From: Simon Davis
Sent: 21 May 2019 16:07
To: 'Lauren Wiltshire' [REDACTED]
Cc: Laura Gibbons <Laura.Gibbons@arun.gov.uk>
Subject: RE: Planning Consultation on FP/42/19/DOC

Engineers Comments Regarding Condition 7

Site Address: Land off Stanhorn Grove Stanhorn Grove PO22 8FS

Description of Works: Approval of details reserved by condition imposed under ref
FP/171/18/PL relating to Condition Nos
5,6,7,8,9,10,11,12,13,14 & 24.

Project: Wellers Close Hampshire Homes Group	
Drawing: Soft Landscaping Concept	
Date: May 2018	Drawn by: JA
Scale: 1:200 @ A1	Revision: -

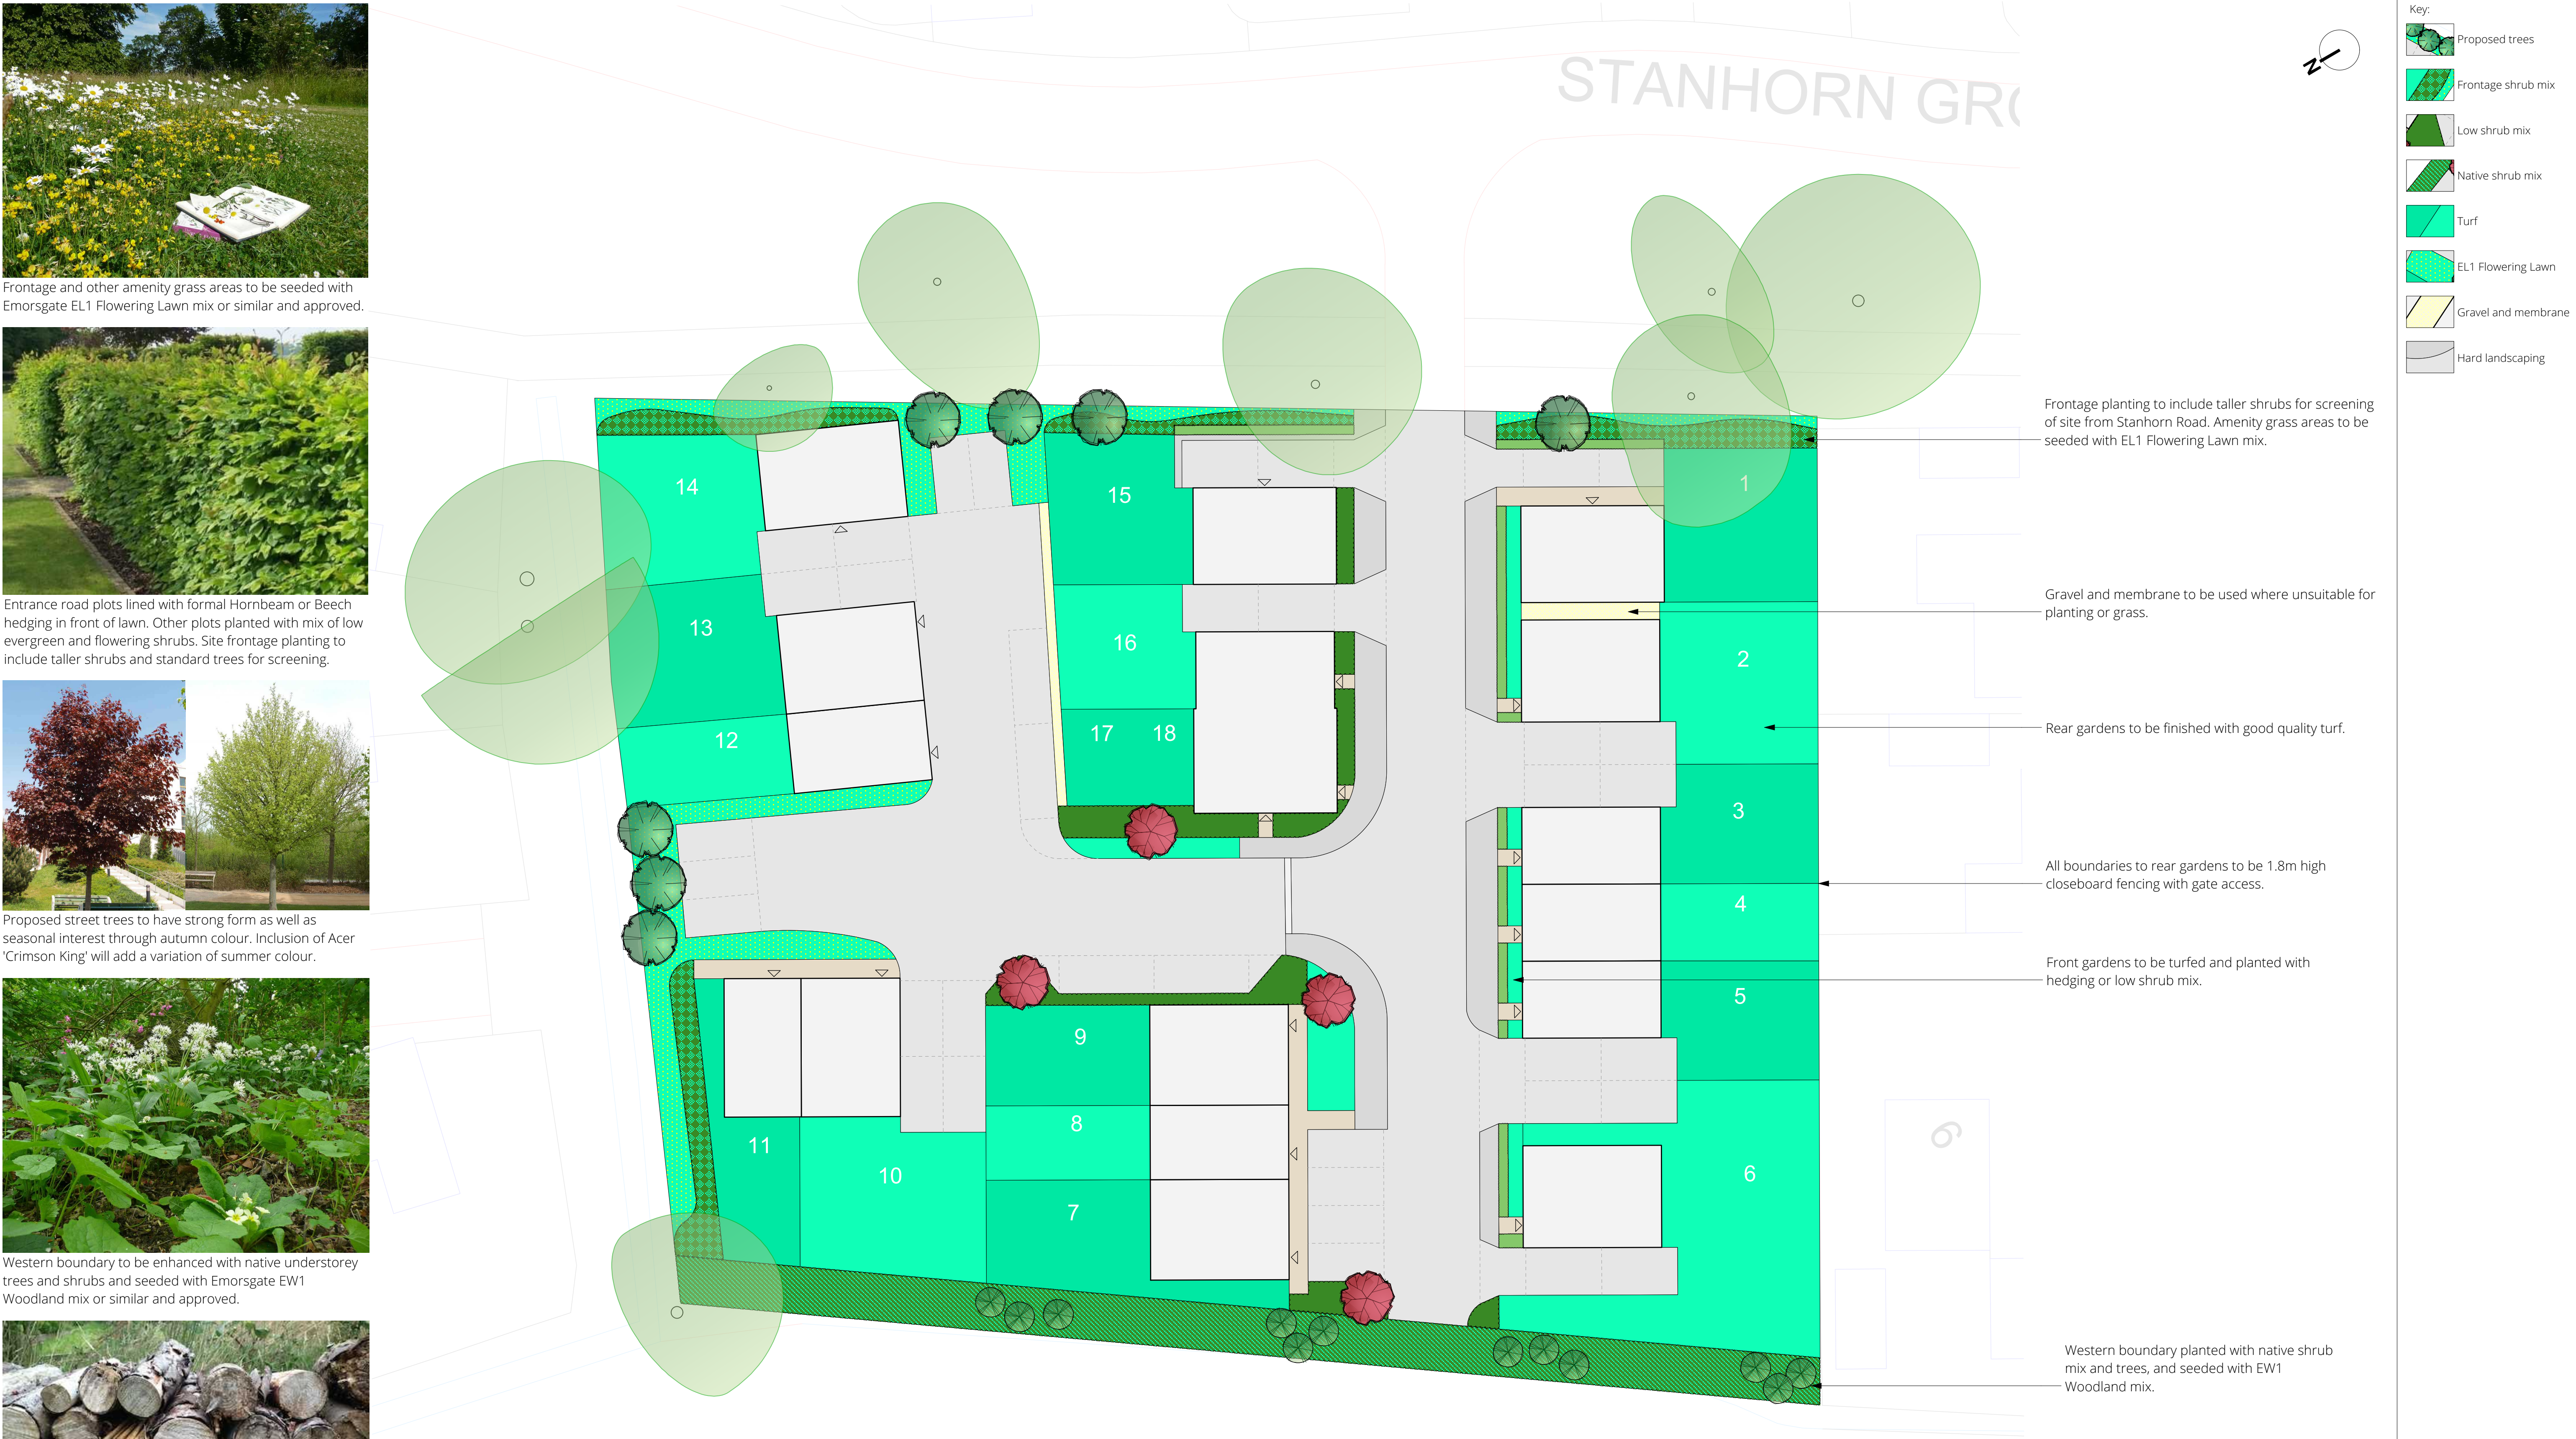
1. Catchpits must be provided upstream of all connections into the attenuation tank.
2. No construction detail drawings have been provided. Please provide construction detail drawings of manholes, catchpits, permeable paving, attenuation tank and hydrobrake.
3. There is conflict between the landscaping proposals and the drainage proposals. Trees must not be located on or near attenuation tanks. Please revise the landscaping proposals.

Rev.	Date	Note	Author	Checked
A	11/06/19	De-mountable fence indicated to rear of Plots 12 - 14	RR	JP

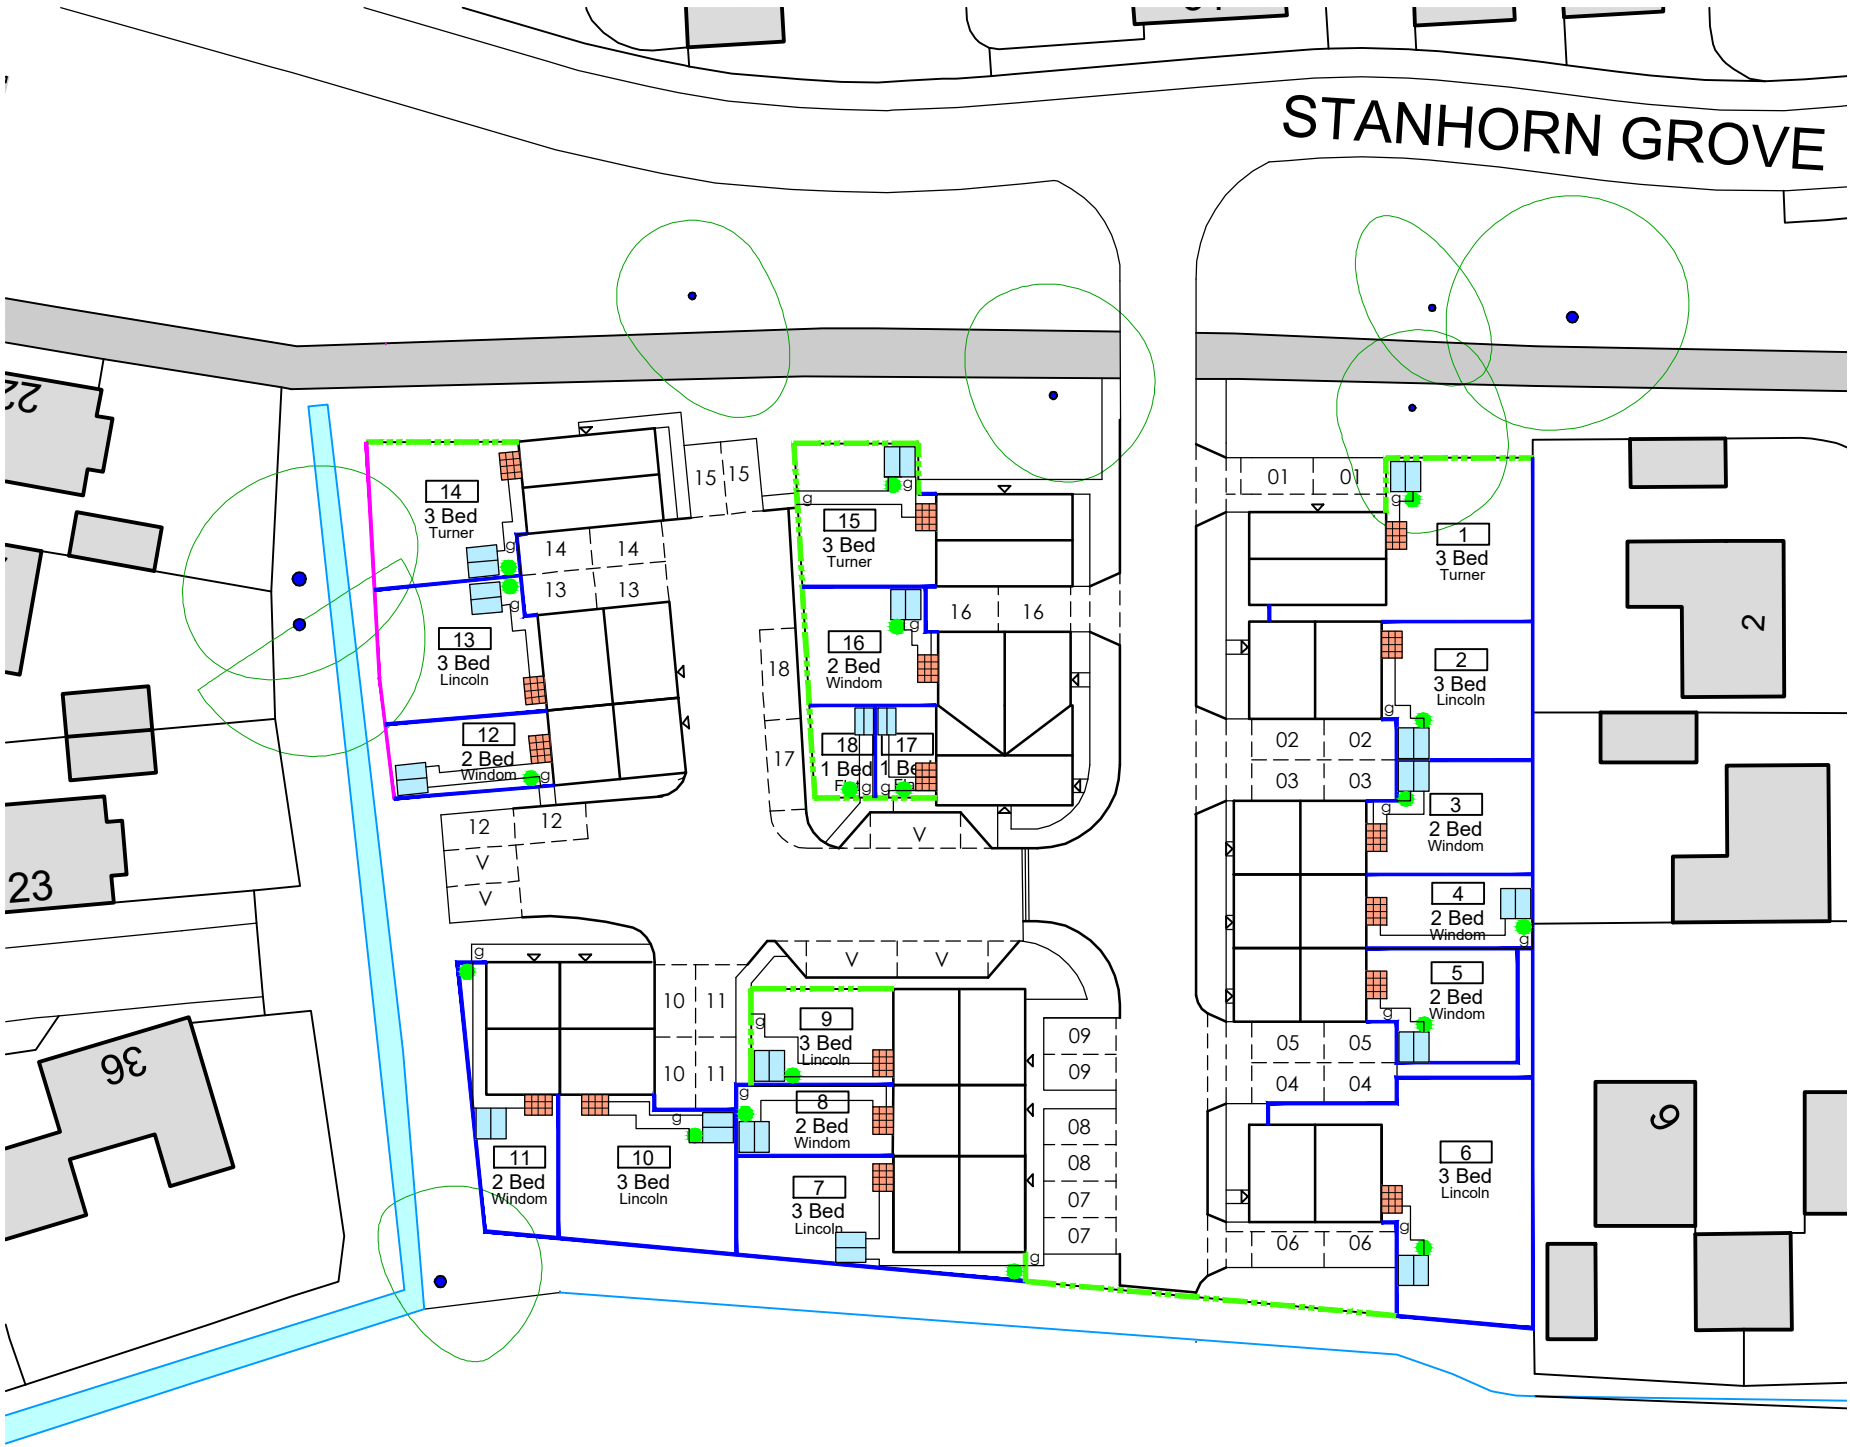
Proposed property boundaries for plots 12-14 need to be amended to allow access to the watercourse. 3m easement is required from any building, fence or wall and the top of bank of an ordinary watercourse.
